City of Colorado Springs-Tutt Road and Cottonwood Drainage Project,
EX-19-001

Please accept the following comments from El Paso County Public Health for the project referenced above:

CONDITIONS CREATED PER THIS EXEMPTION SURVEY PLAT

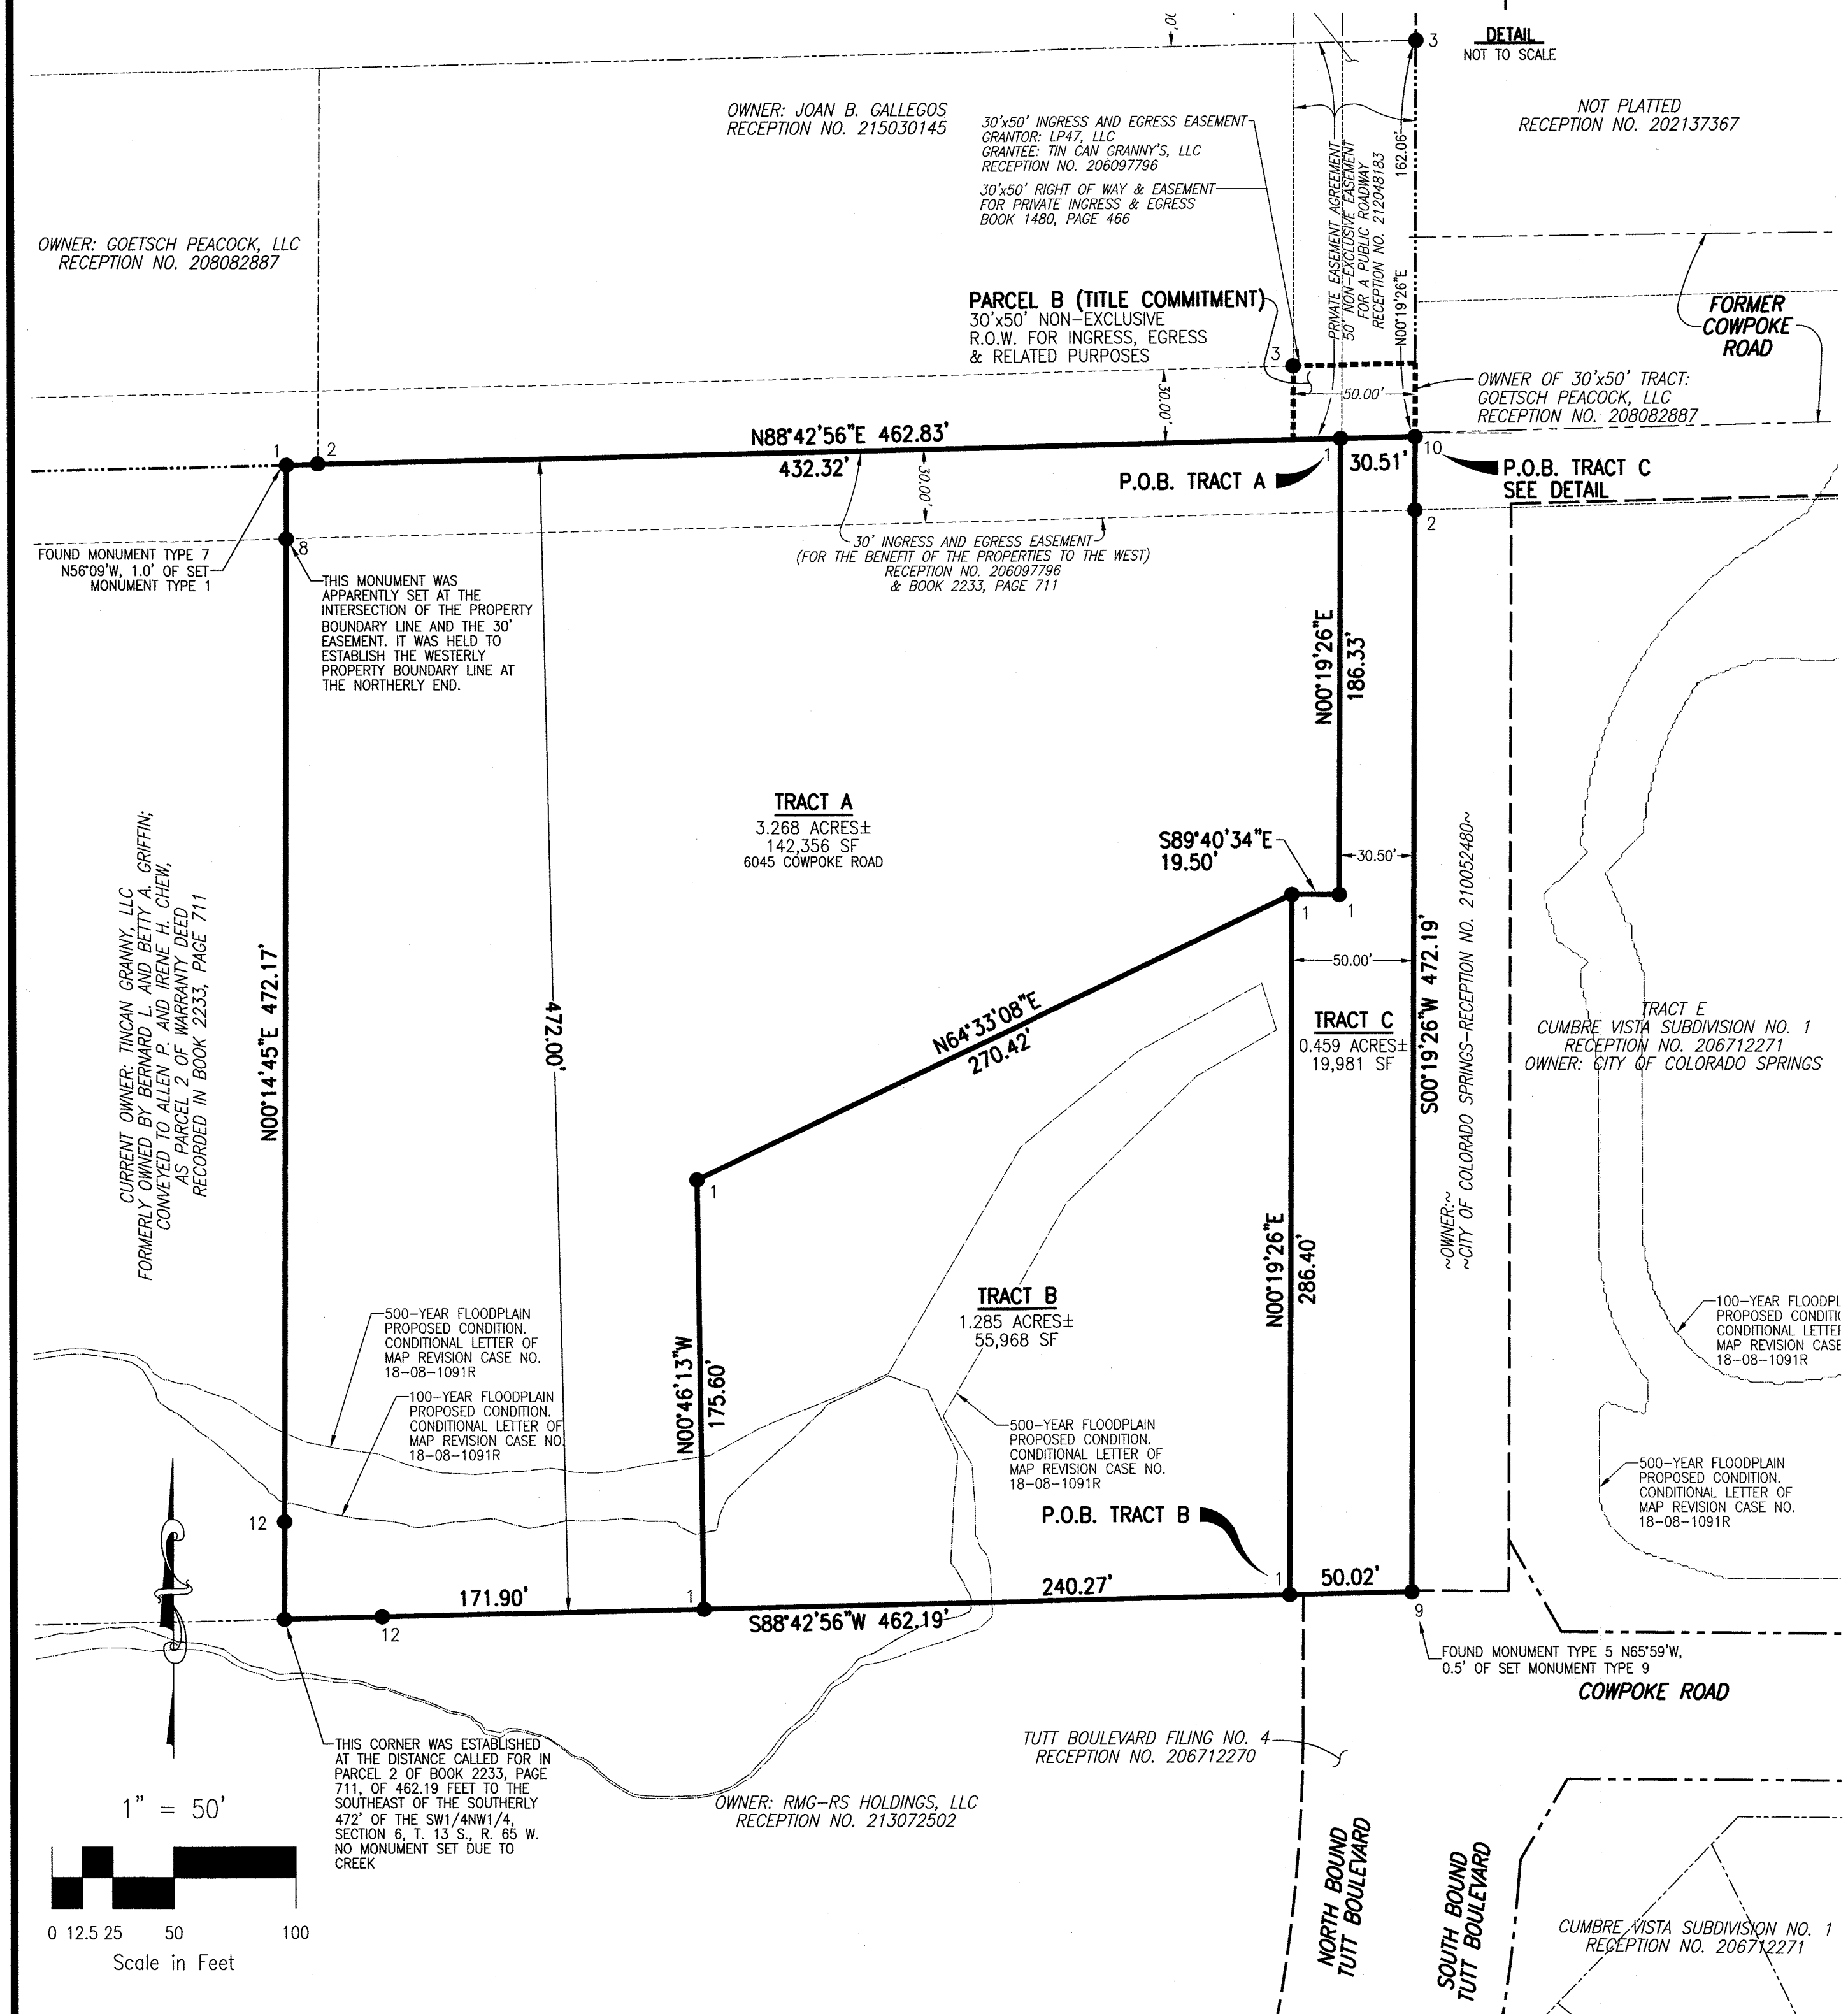
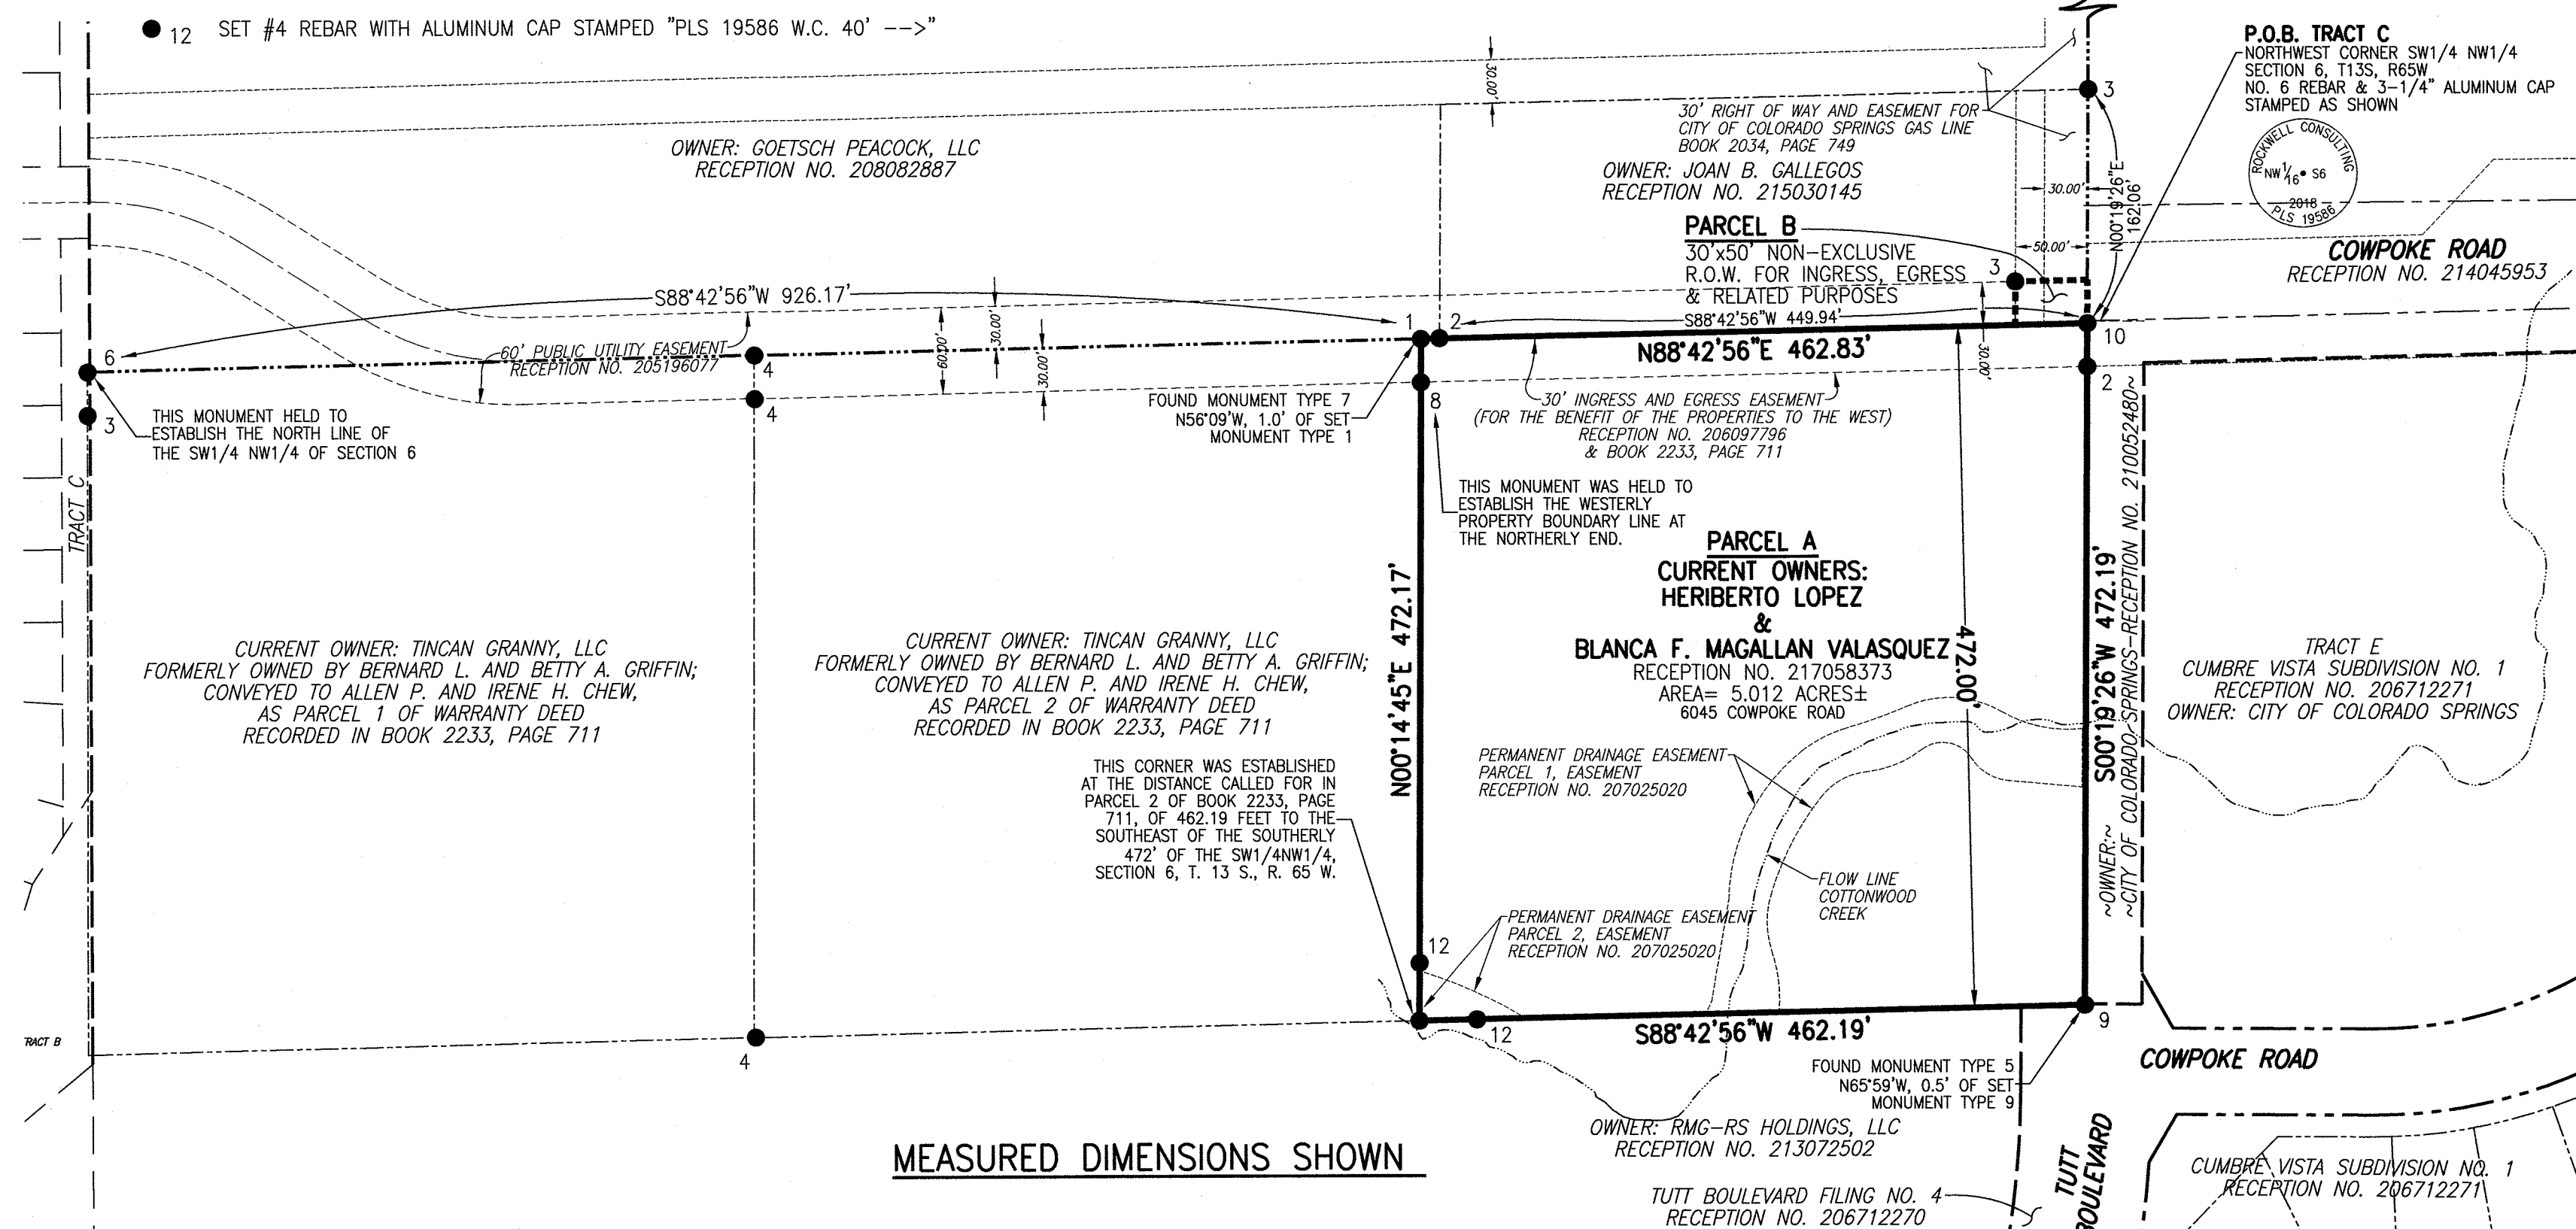
- The existing onsite wastewater treatment system (OWTS) must be entirely located on the remaining 3+ acres and meet all minimum horizontal installation setbacks found in the El Paso County Board of Health, Chapter 8, Onsite Wastewater Treatment System Regulations. This includes the location of the well.
- No other public health issues noted with the smaller lot if the above condition is satisfied.
